Our ref: New Primary School at Gregory Hills (SSD-41306367)

22 December 2022

**Subject:** Response to Submissions

APPENDIX A – LOCATION OF WASTE STORAGE PAD (YELLOW)

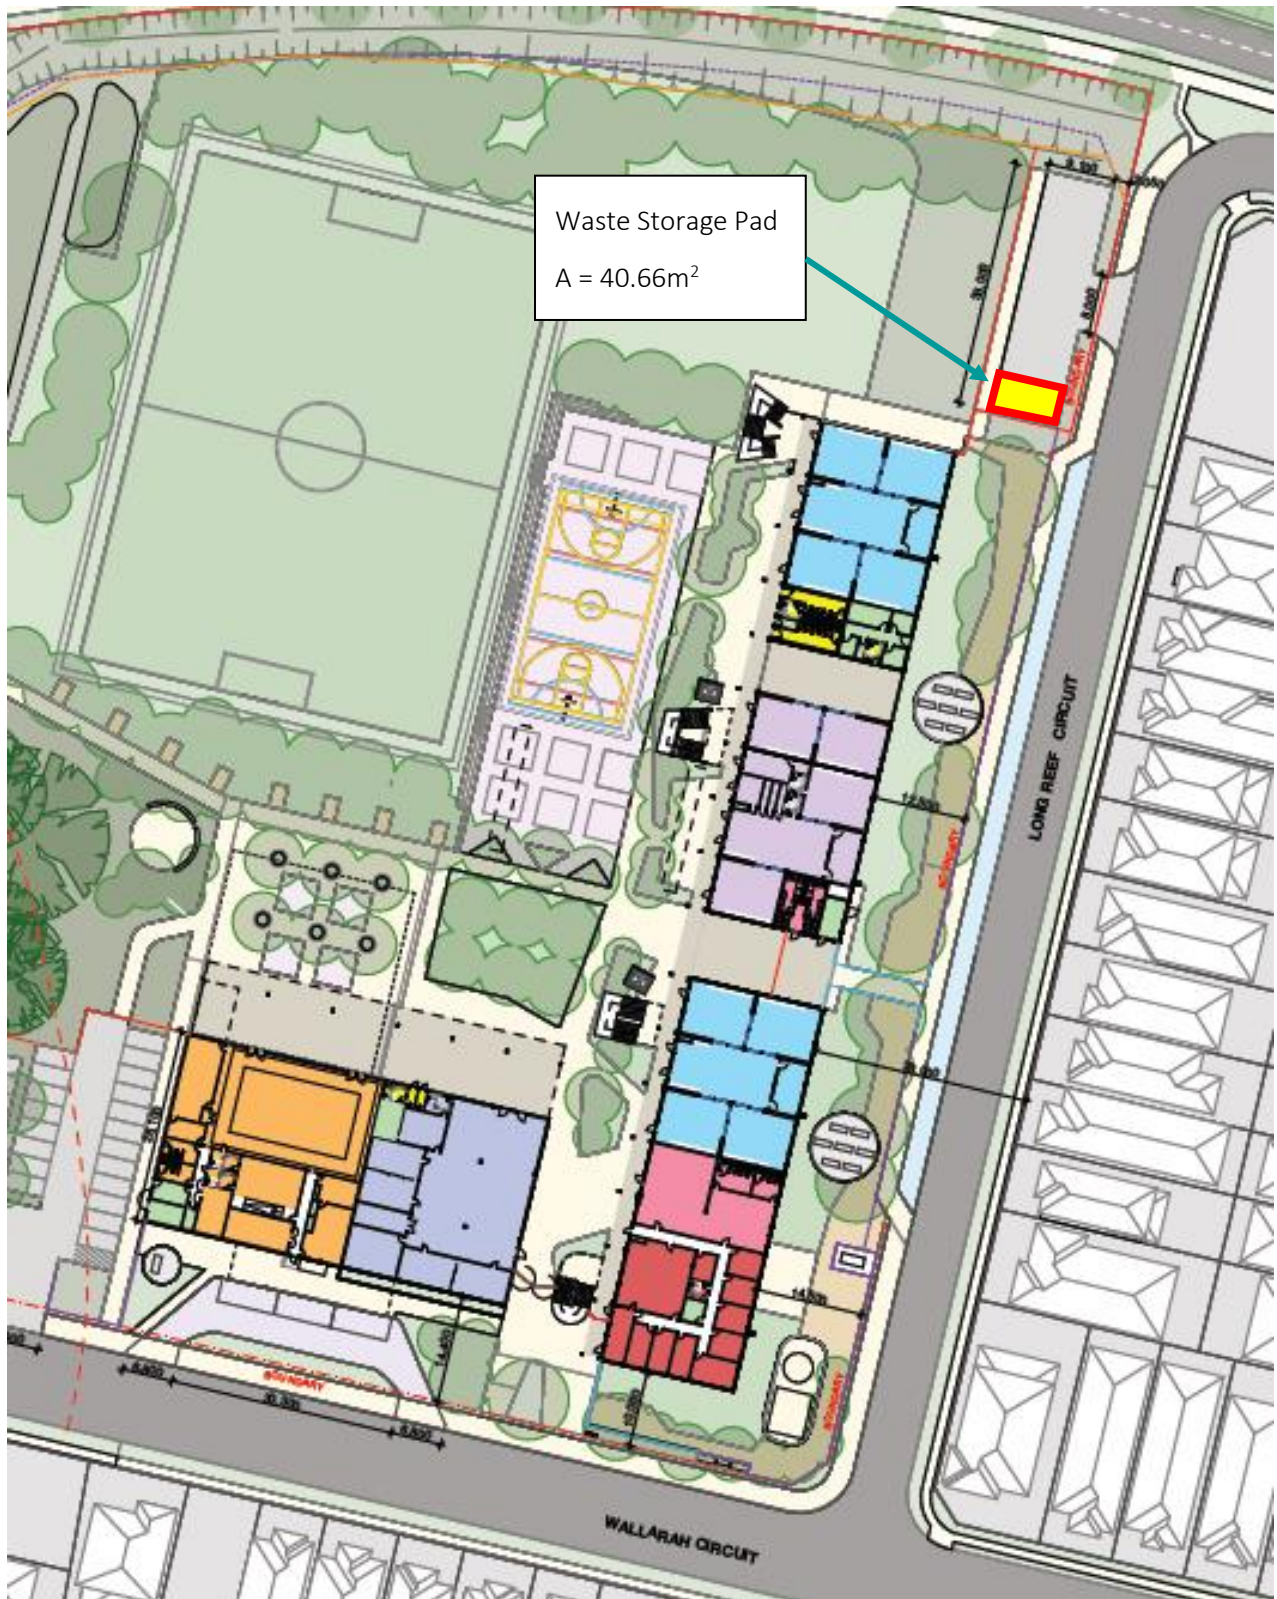
- The EIS seeks to use the waste pad/loading area approved under DA 2022/742/1. However, the layout of the waste pad on the submitted plans is different to what was approved under the Council DA. Provide clarification of the approval pathway and if necessary, include in the description of the proposal.

Figure 17: Pedestrian Access Concept Plan

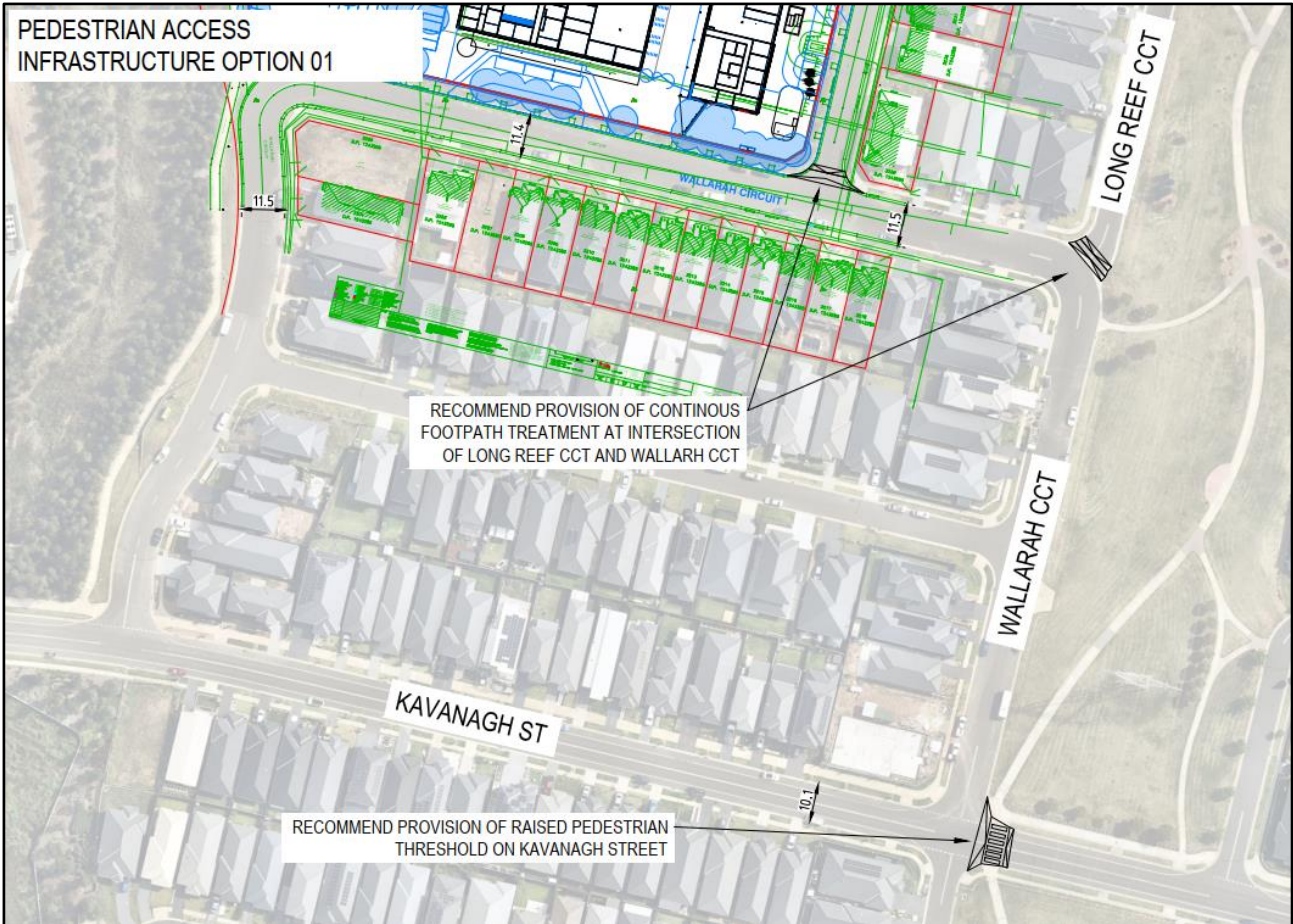
- Table 23 of the Transport and Accessibility Impact Assessment (TAIA) is missing data under 'proposed development' in the analysis of walking space level of service.
- The TAIA and the EIS provide conflicting information in relation to the widening of the footpaths. The TAIA indicates 3 metre wide footpaths are proposed along Wallarah Circuit and Long Reef Circuit as part of DA/2022/742/1. The EIS indicates differently. Clarification is required.
- The provision of pedestrian infrastructure is unclear. The appendices to the TAIA make numerous references to the provision of pedestrian crossings at the intersections of Long Reef Circuit and Wallarah Circuit, and Kavanagh Street and Wallarah Circuit. TfNSW in their

response to the EIS have also made comments in relation to these crossings. However, the TAlA does not discuss the proposed crossings, their purpose or the implications of them not being delivered. Clarification is required.
